From: [REDACTED]
To: [M25 Junction 28](#)
Subject: Gardens of Peace - comments on responses to Written Representation
Date: 25 February 2021 19:40:22
Attachments: [20200225 - Comments on Responses to WR's - Final.pdf](#)

Savills, on behalf of Gardens of Peace Muslim Cemetery, submit the following comments in regards to Highways England's response to the Written Representation. We first outline our comments to each specific response (Part 1), before providing a key summary of comments on Highways England's Responses (Part 2). We reserve the right to discuss the below points, and the concerns highlighted within the Written Representation, in greater detail during the oral hearing.

Project Title	M25 Junction 28
Drawing Title	FIGURE 6.6 PREDICTED DAYTIME ROAD TRAFFIC NOISE LEVELS, DS22
Drawing Number	Project: HE551519 - ATK - ENV Originator: XX - GS - GI - 000006 Volume: ---
Original Size: A3	Scale: 1:12,500 Project Ref. No: --- Sheet: 1 of 1 Rev: C03

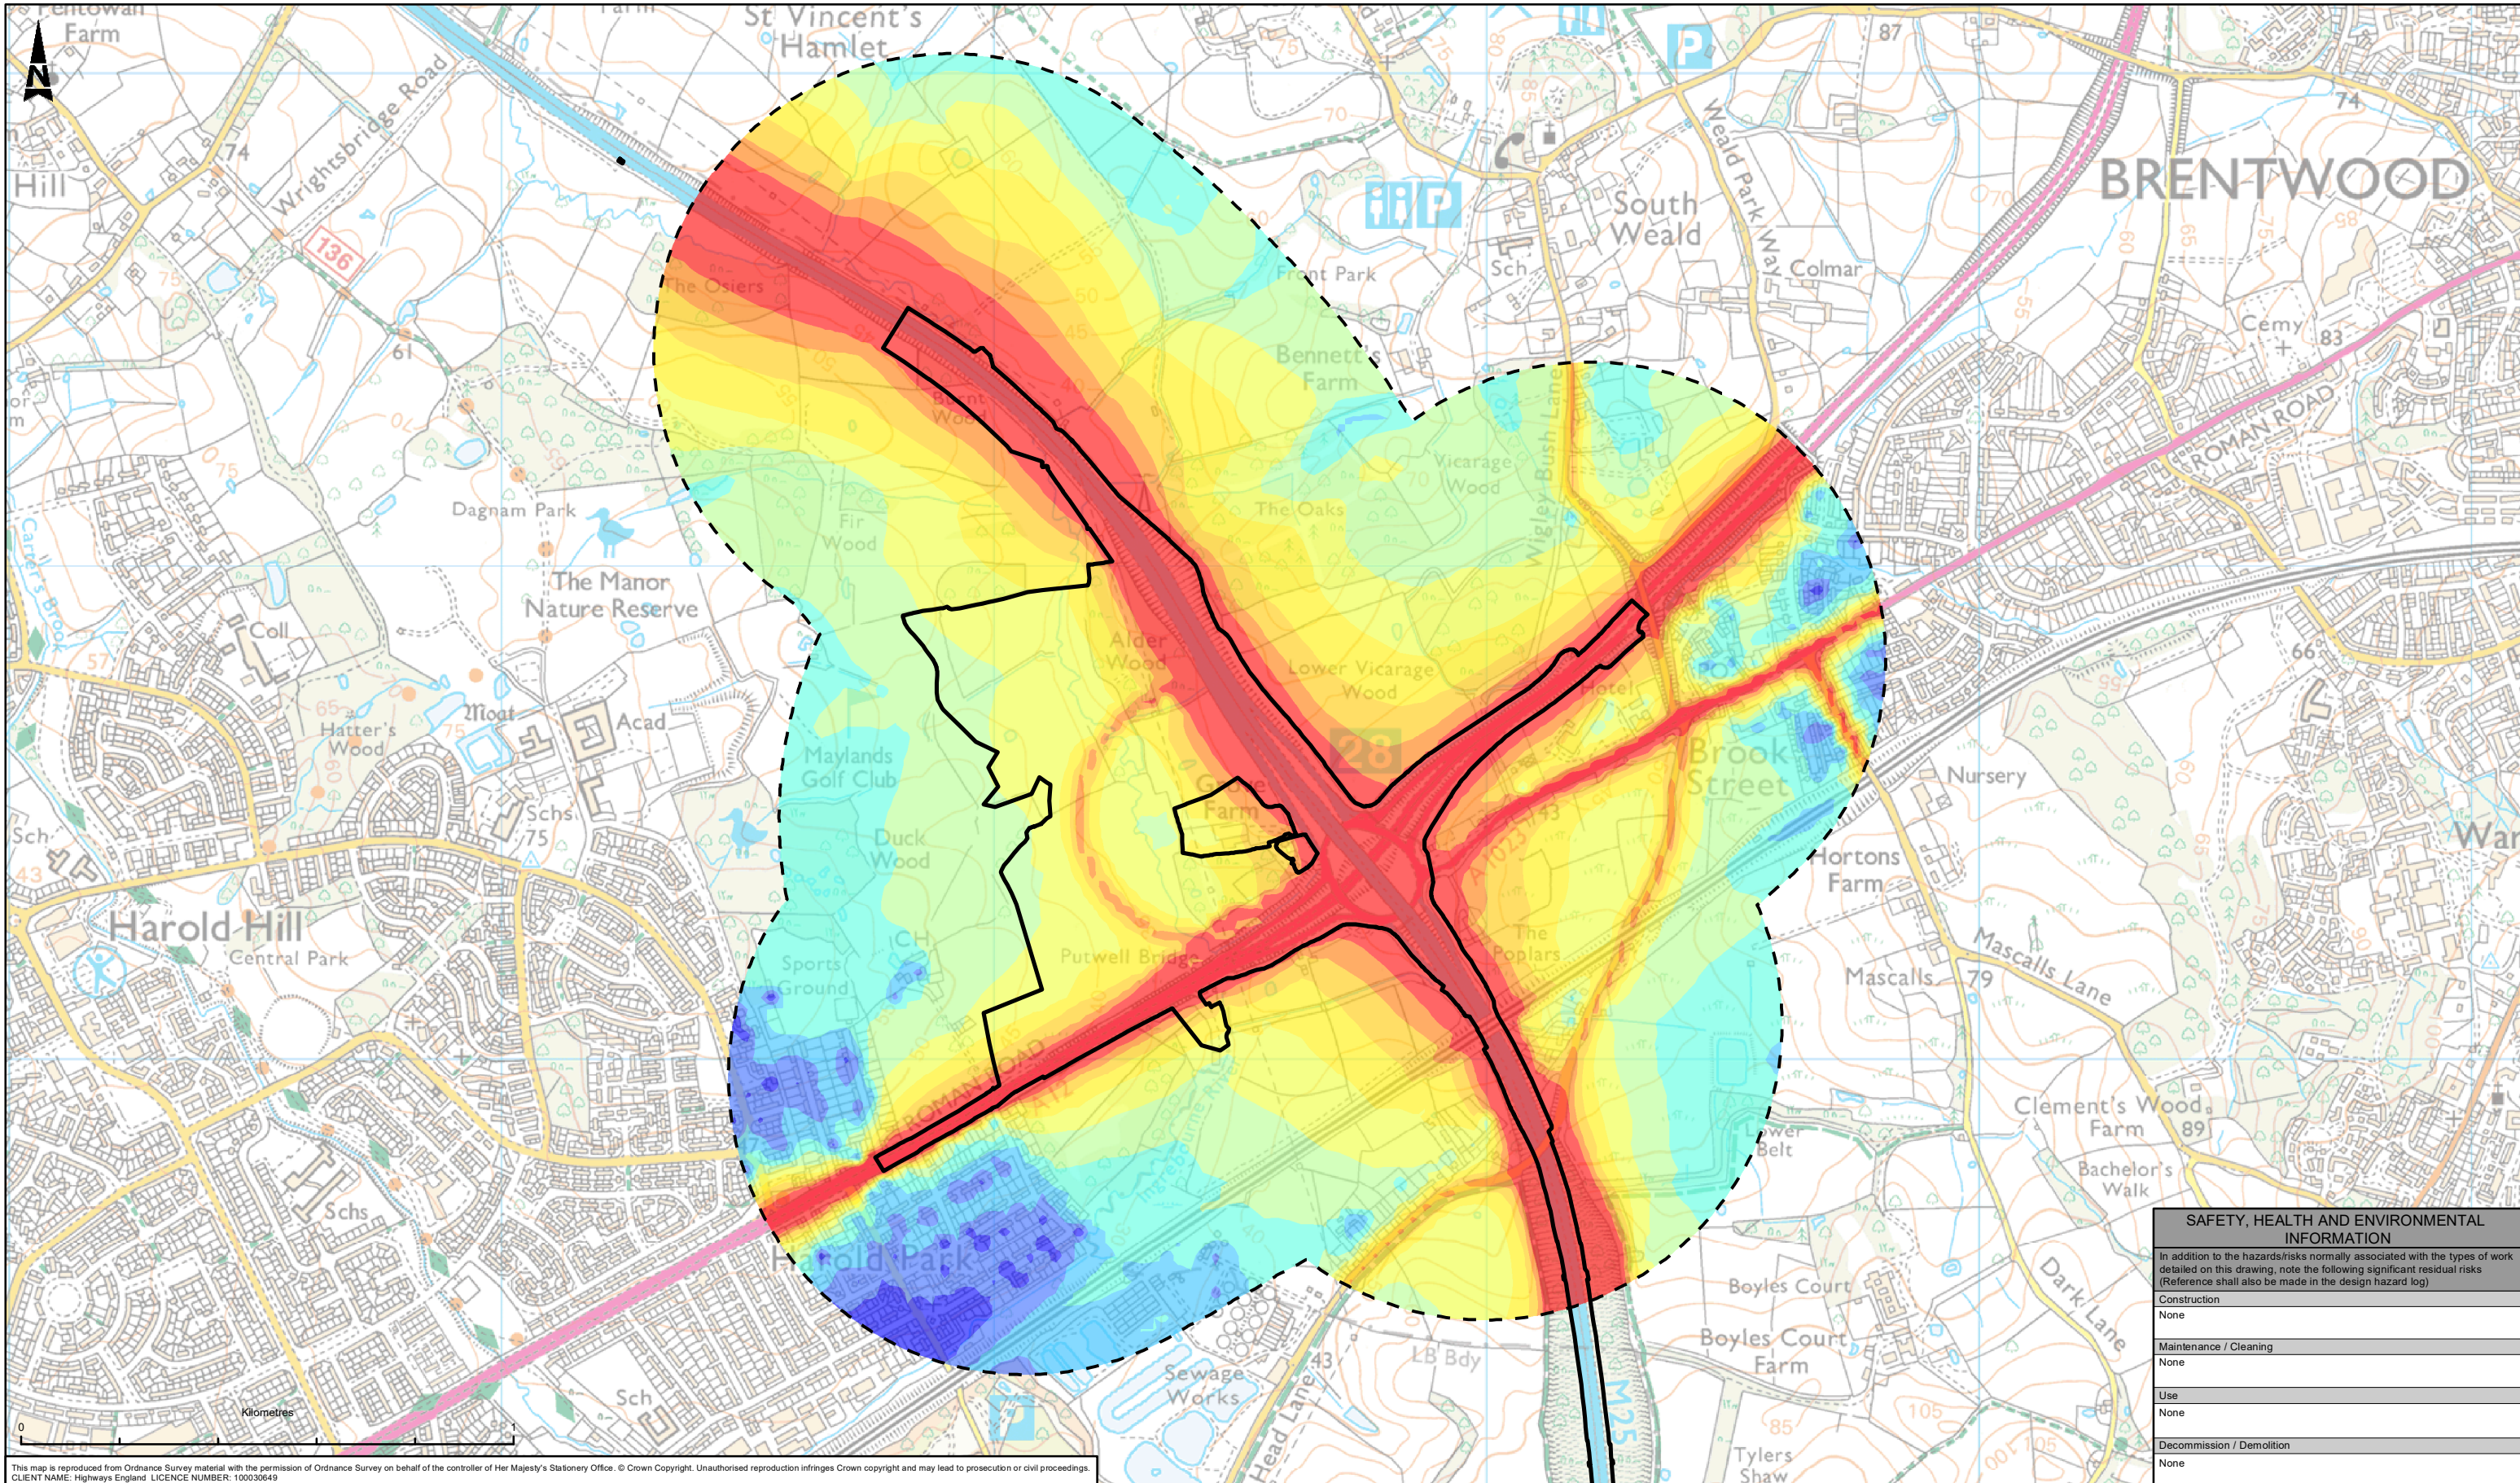
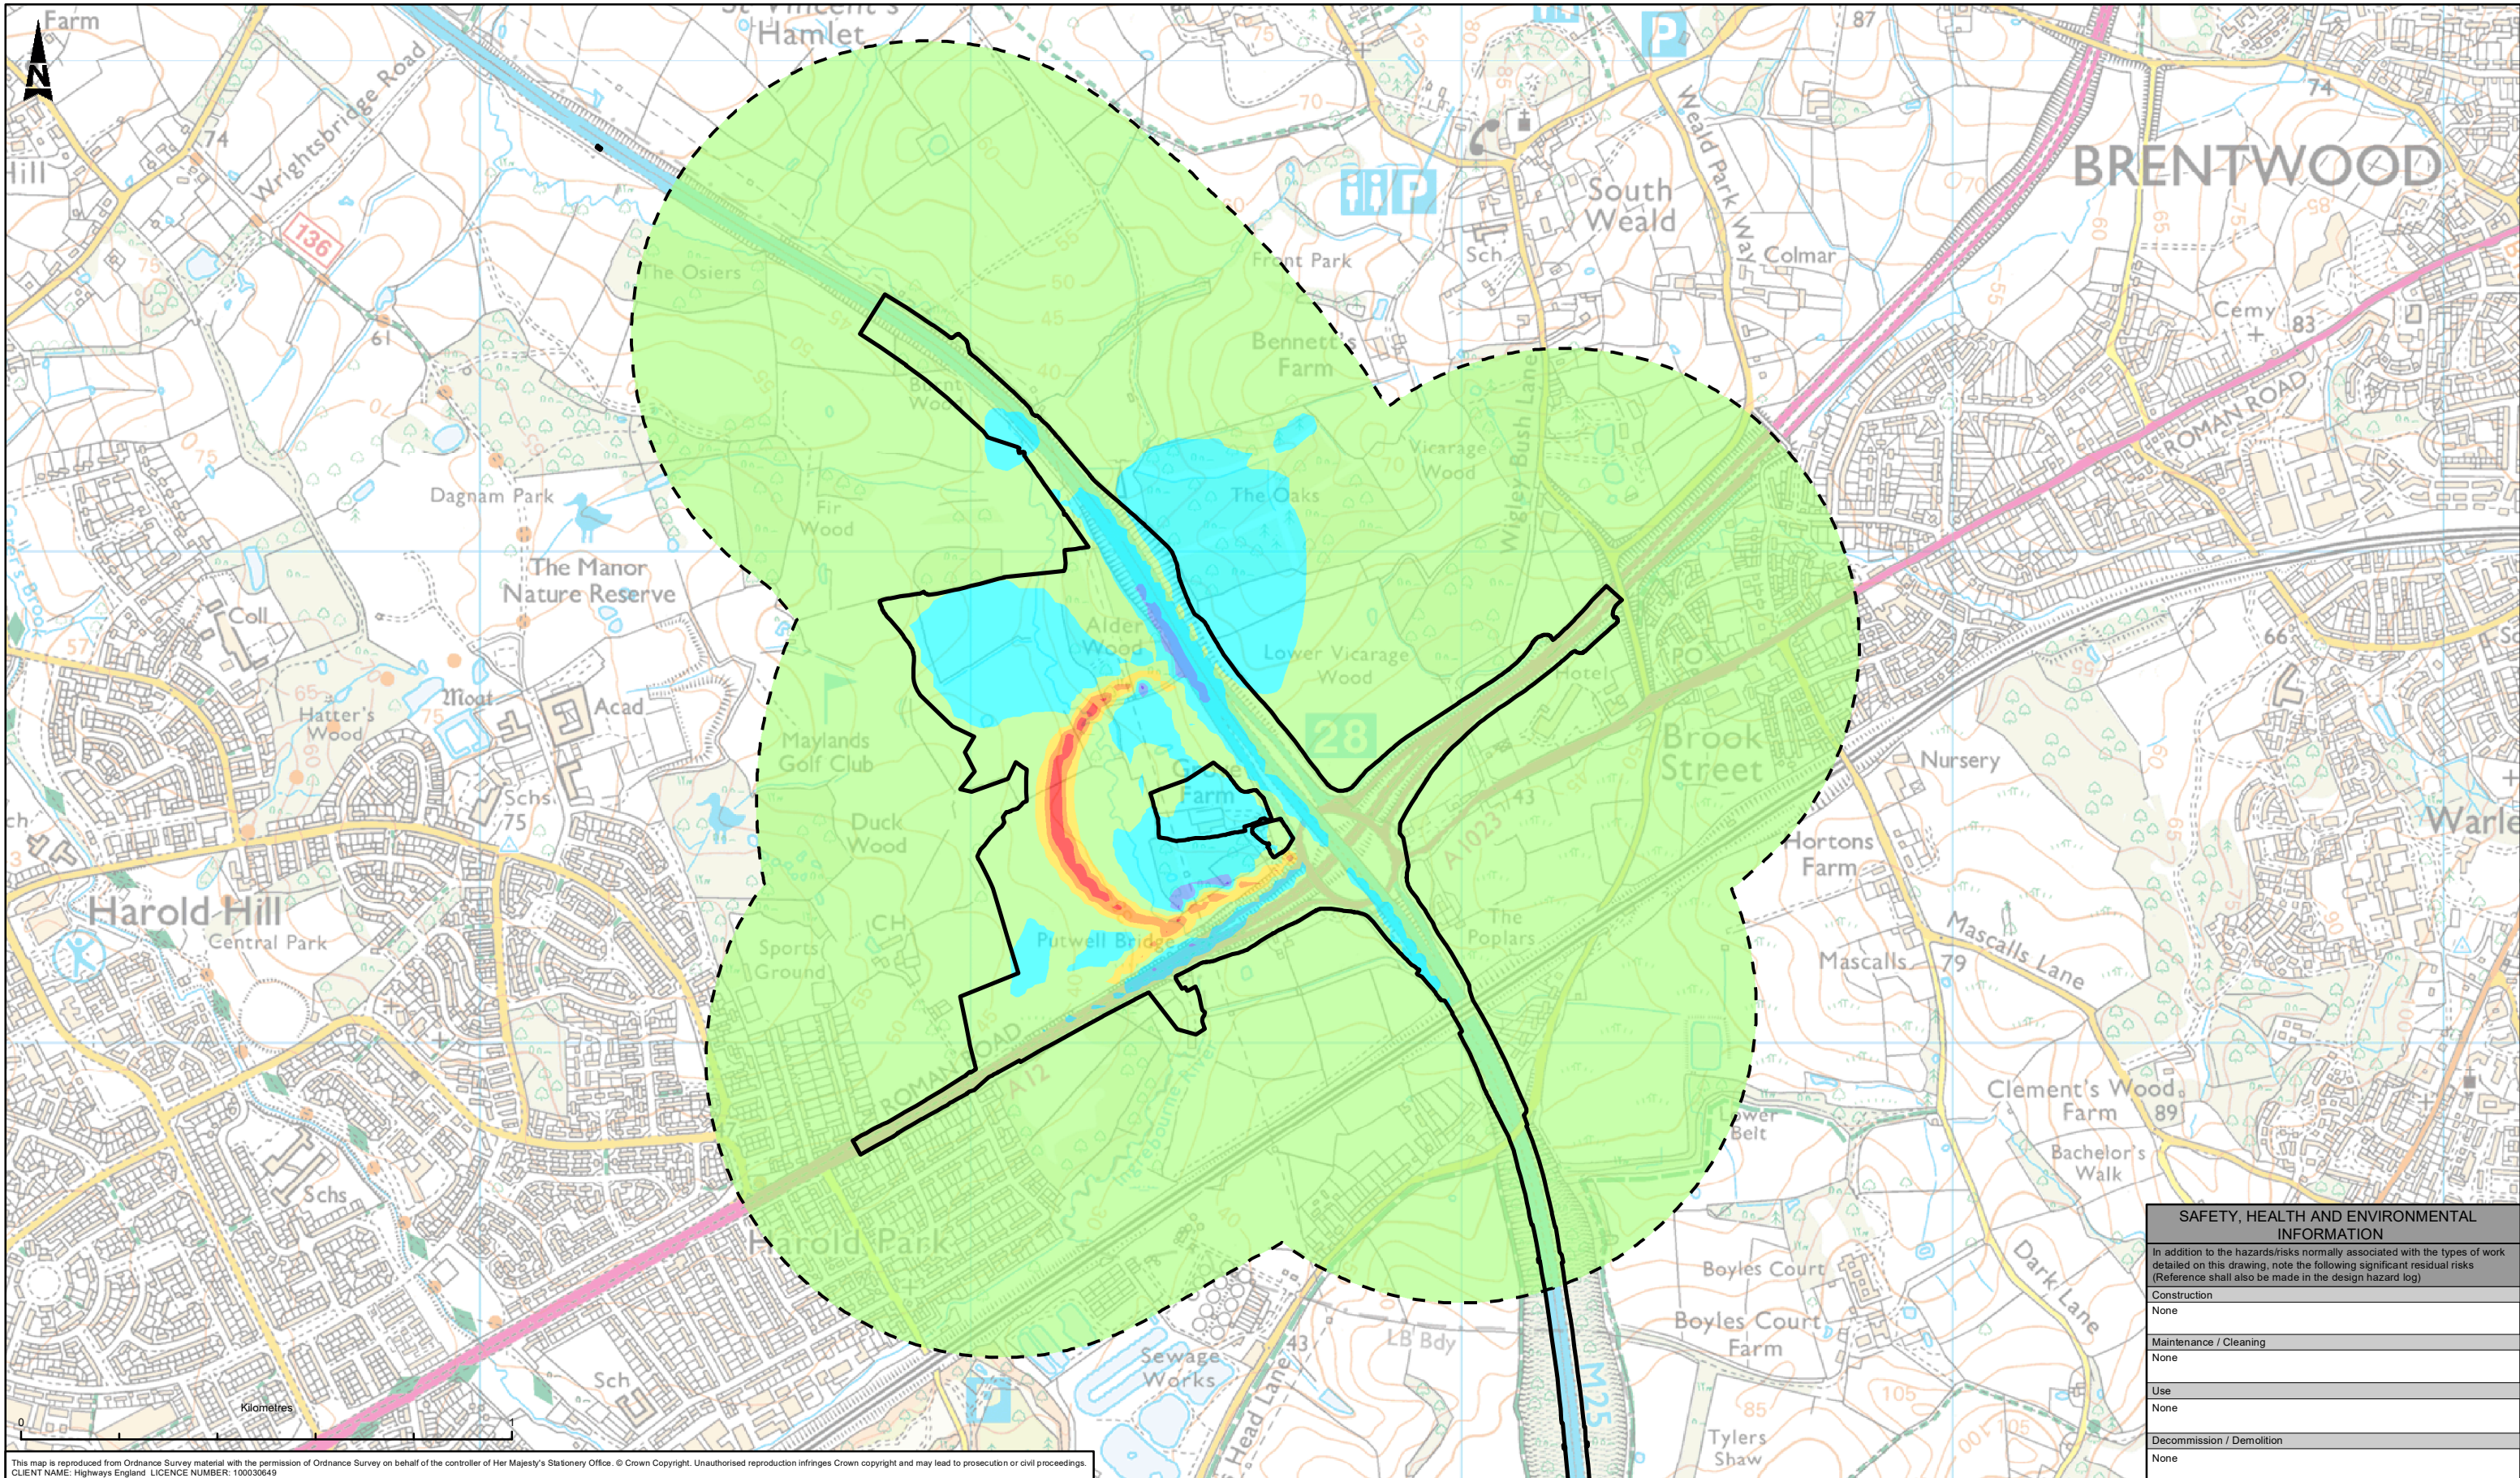
Gardens of Peace welcome the clarification on the expected reduction in noise level of 1dB.

The noise impacts at the Gardens of Peace can be seen on the noise contours in the ES (Figures 6.5 to 6.15, APP-041), and the impacts are summarised in point 12.1.1 of the Statement of Common Ground with London Borough of Havering (REP1-004). For further clarity a receptor position has been added for the Gardens of Peace and this is presented in the update of the Noise Chapter 6 of the ES (TR010029/APP/6.1(2)) submitted at this Deadline 3a. The Gardens of Peace receptor is included in the tables of receptors in the updated Appendix 6.3 (TR010029/APP/6.3(2)) submitted at Deadline 3a. The table below is extracting the noise results from Table 6.1 of the updated Appendix 6.3 (TR010029/APP/6.3(2)). The changes in noise expected at the Gardens of Peace are decreases in noise smaller than 1dB.
